FIVE ESTUARIES OFFSHORE WIND FARM

**Appendix I6 Natural England's Comments on 10.29 Applicant's Comments on  
Deadline 3 Submissions [REP4-040]**

Planning Inspectorate Reference EN010115

11 February 2025

Figure 10.34e
 Viewpoint 9: Orfordness (Roof - Bomb Ballistics Building)
 Five Estuaries

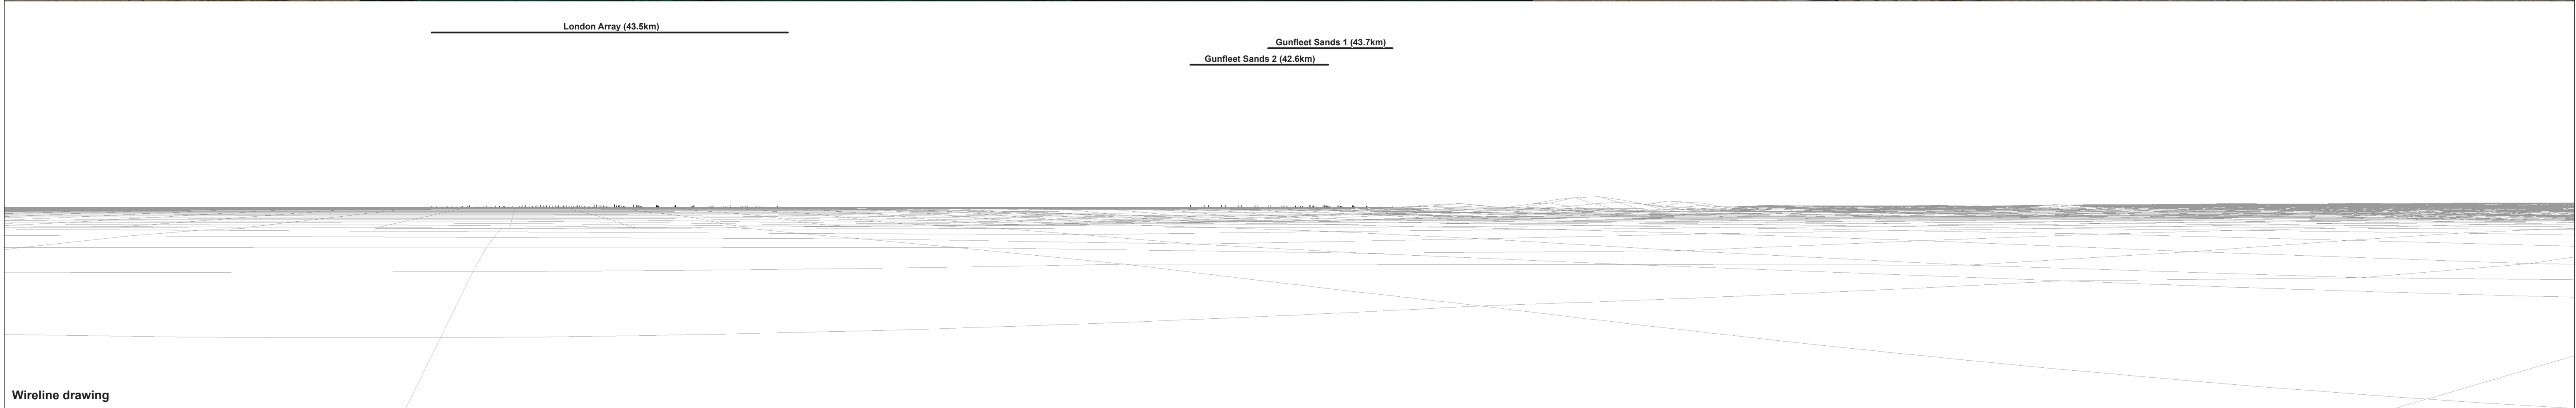
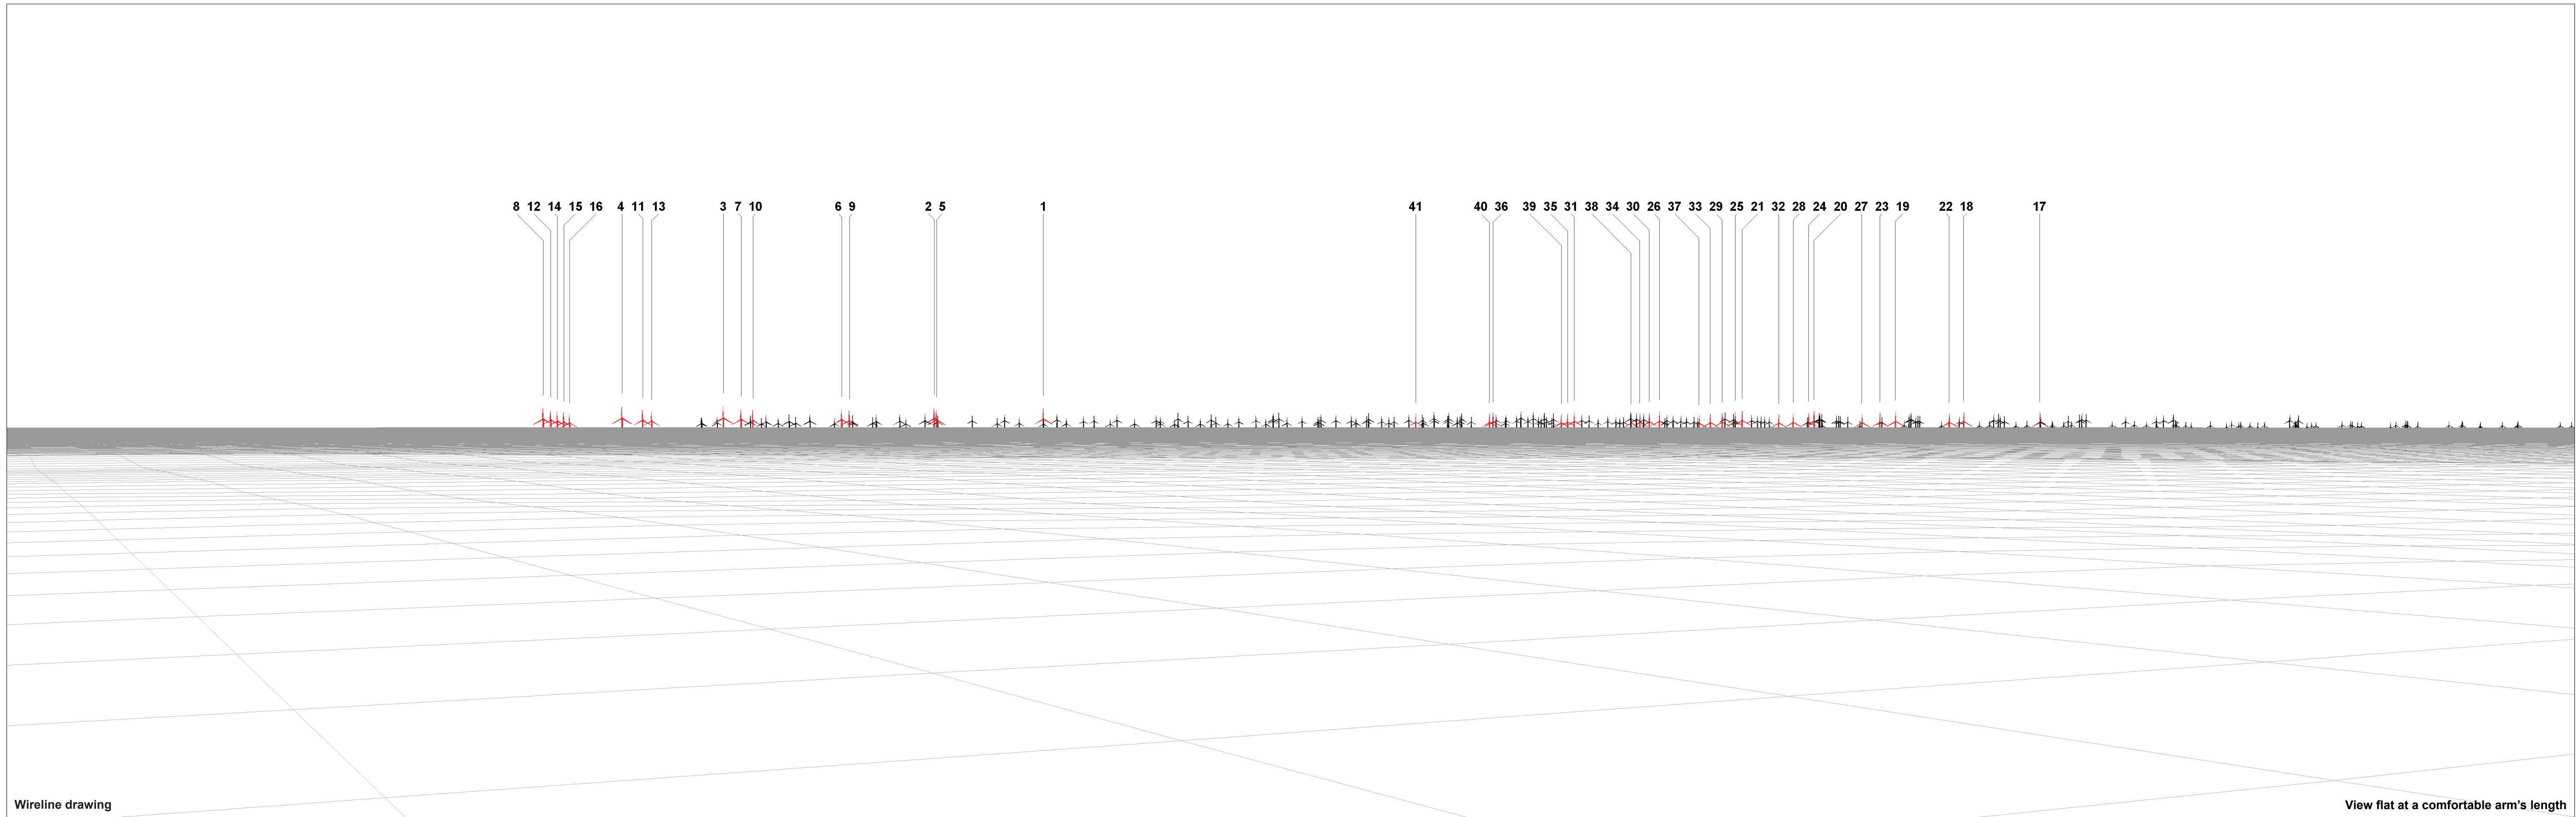
Please see the revised Table 1 below which provides indicative apparent heights in degrees for the 370m MDS scenario in an additional column, which is shaded orange. We highlight that for five viewpoints the apparent heights remain above 0.4 degrees i.e. above a level that Natural England considered to be potentially significant.

In particular, we draw the Examiners' attention to the value for the viewpoint located on Orford Ness, which should be considered in the context of the highly sensitive nature of this location, principally in terms of potential for significant adverse effects to the SCHAONB (now SCHNL) wildness and tranquillity special qualities.
